DELEGATED DECISION

Address: 117 PINNER ROAD NORTHWOOD

Development: Erection of an additional floor to create 4no. flats above existing residential upper and ground floor retail (Application for Prior Approval under Schedule 2, Part 20, Class AA of the Town and Country Planning (General Permitted Development) (England) Order 2015 (as amended))

LBH Ref Nos: 12055/APP/2025/2416

D	19.08.25	Removal of 6th Floor	VM	KV
C	31.05.24	Layout and Facade Adjustment	VM	KV
B	02.03.22	Alter Fourth and Fifth Floor Plan, Elevation and Section	AV	KV
A	16.12.21	Revision to Planning Consultant's Comment	AV	KV

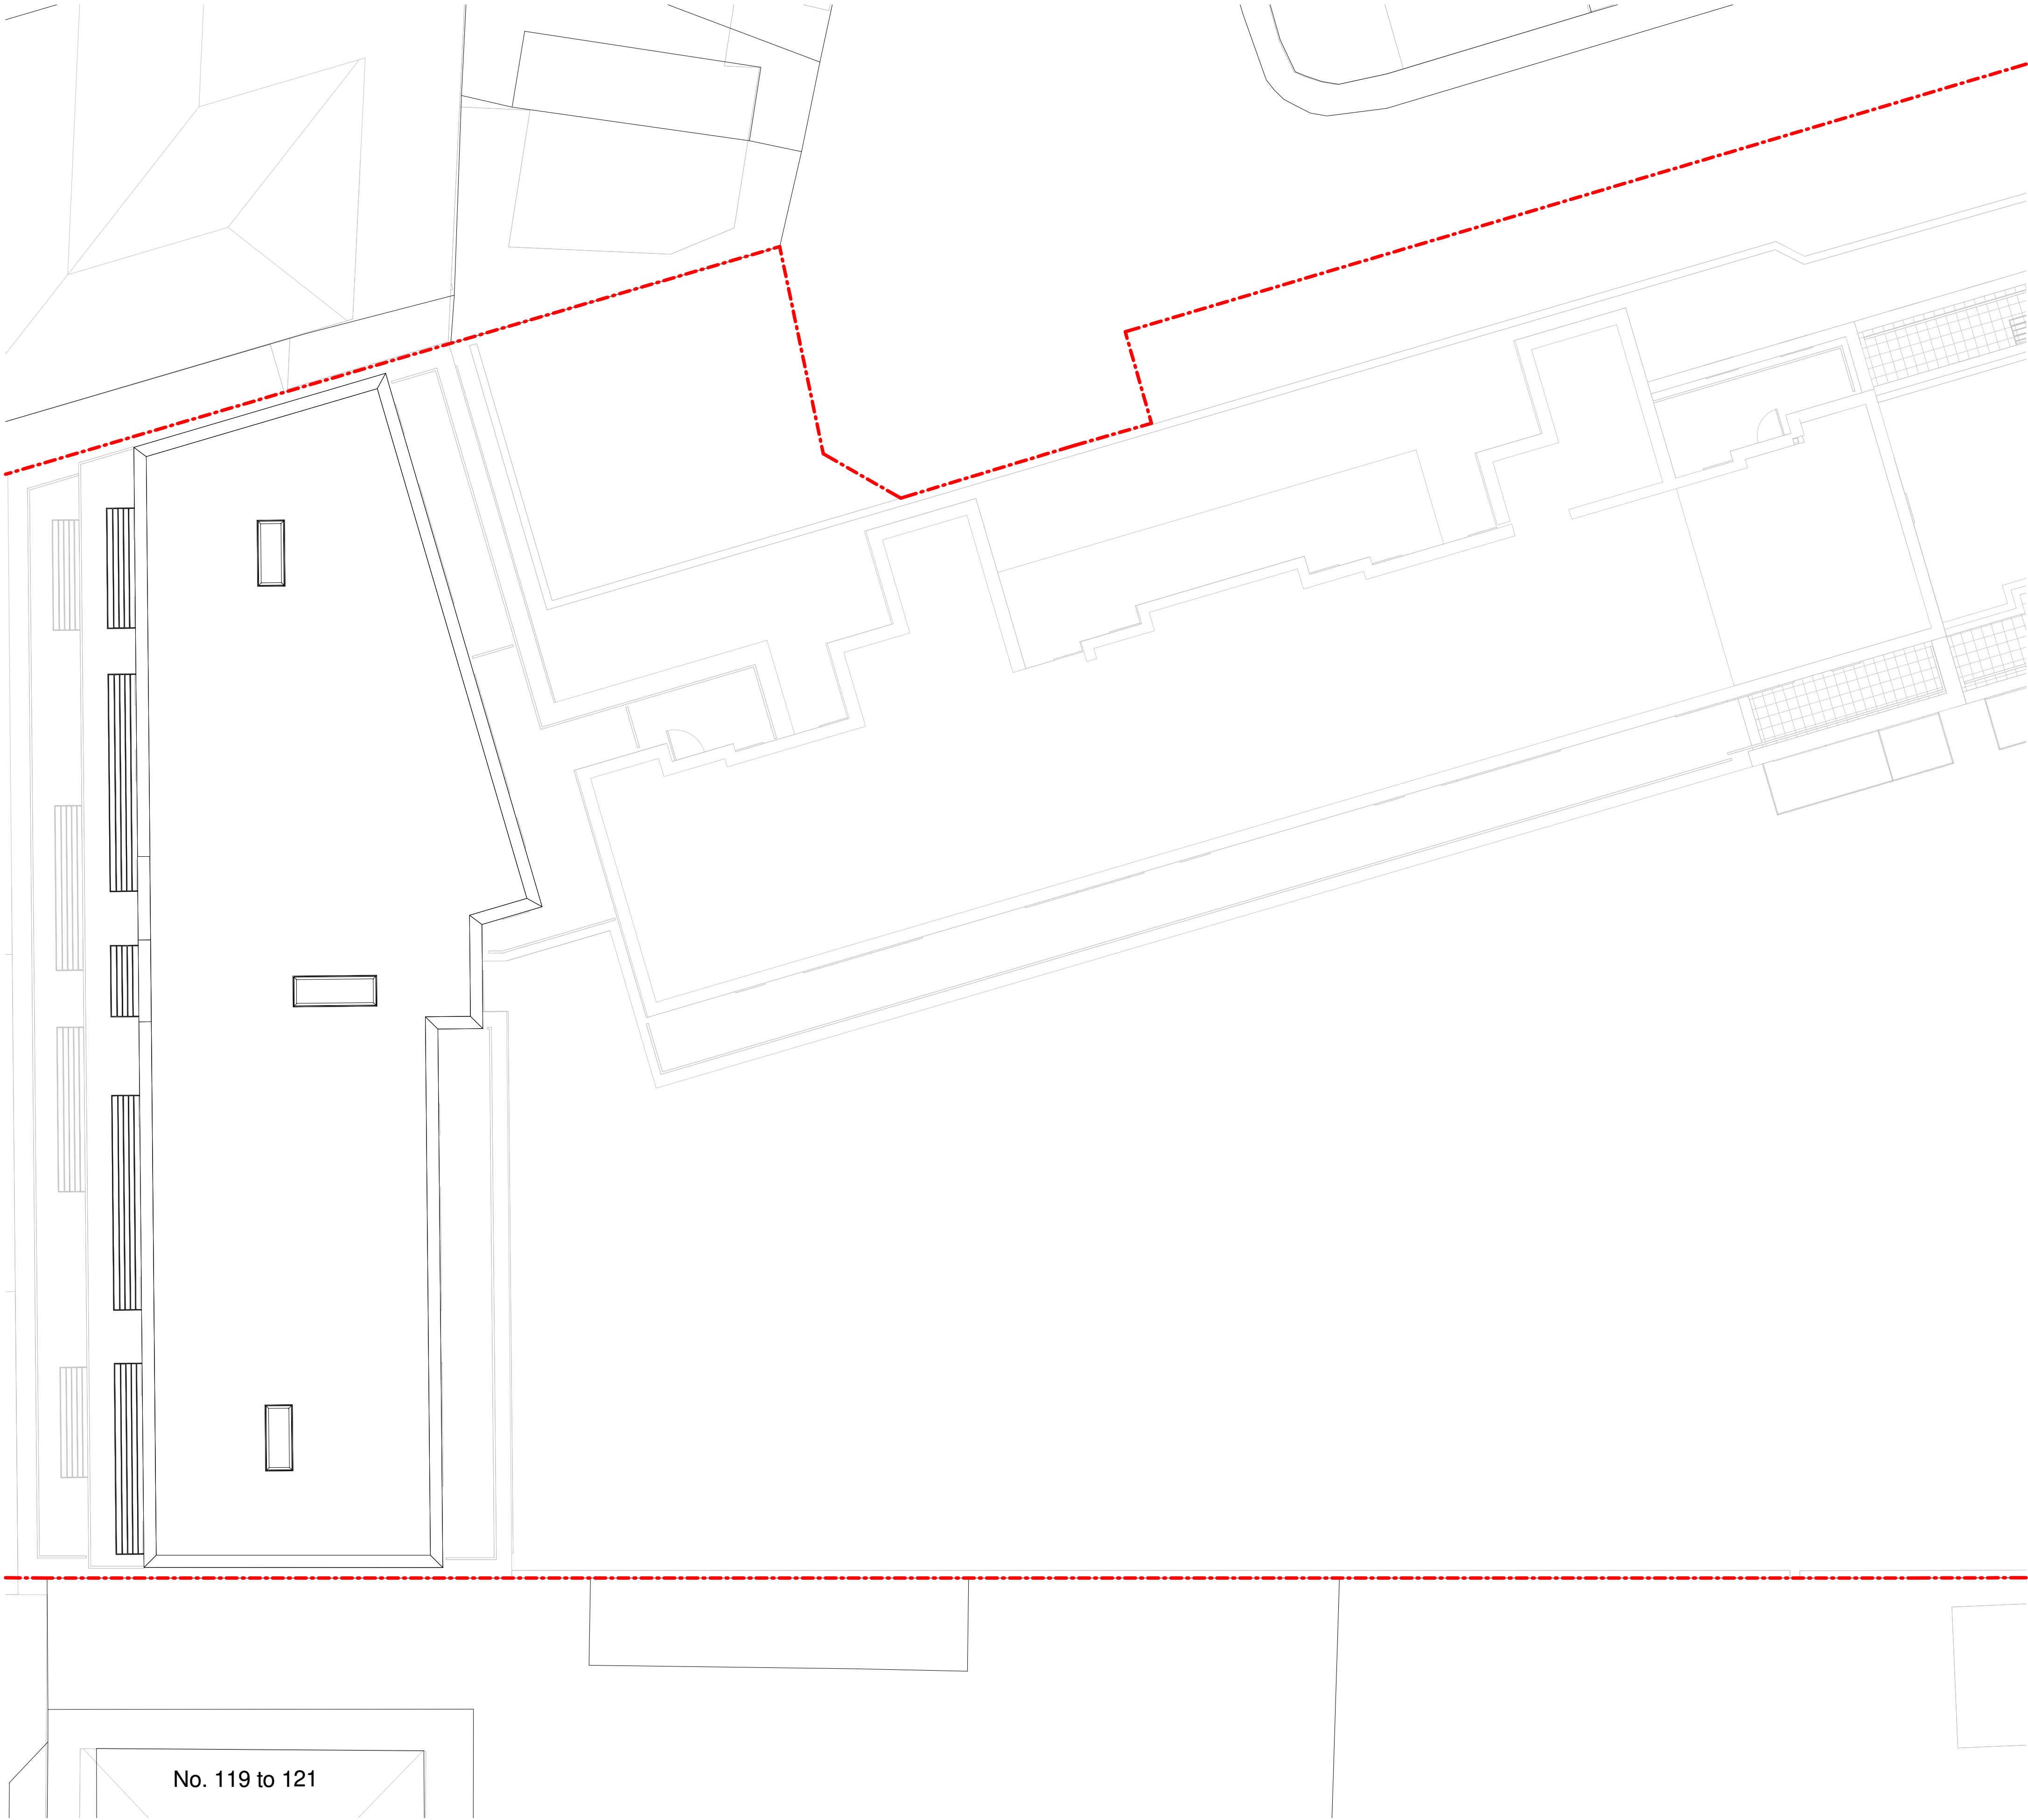
The proposed addition of a further storey would exacerbate the building's prominence, introducing additional height, bulk and visual massing to an already dominant structure. Despite the proposal being reduced to one additional storey (rather than the two previously refused), the increase would nonetheless tip the proportions of the block towards a "top-heavy" form that unbalances its composition.

By virtue of its height, scale, bulk and massing, the proposal would disrupt the architectural composition and rhythm of the host building, and would exacerbate the discordance between the site and its surrounding context. The additional storey would be visually intrusive and harmful to the character and appearance of the wider streetscape.

Proposed Elevation Pinner Area - 5

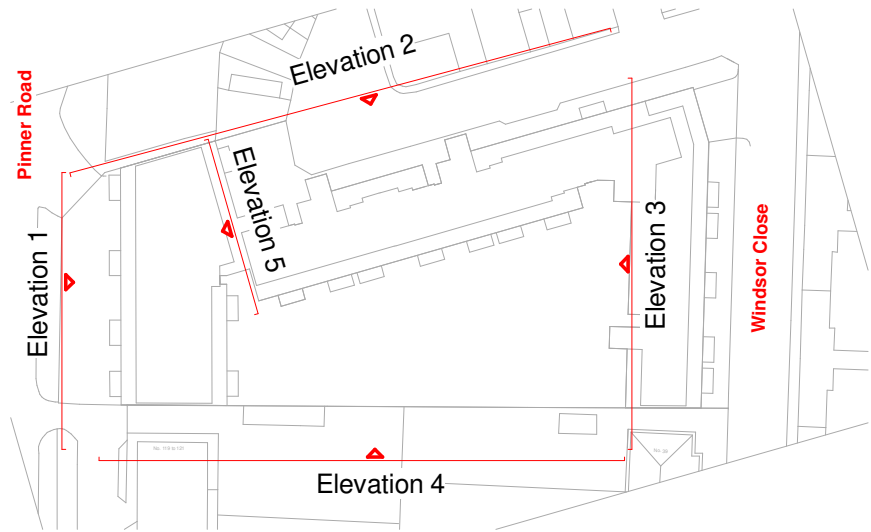
On the principal elevation facing Pinner Road - the most sensitive and publicly visible frontage - the additional storey would accentuate the discordance with the consistent roofline and rhythm of surrounding development. The established character of the local centre relies on buildings of a broadly uniform scale, massing and architectural expression. Any further increase in height on this site would accentuate its divergence from the prevailing townscape and would fail to integrate with its context.
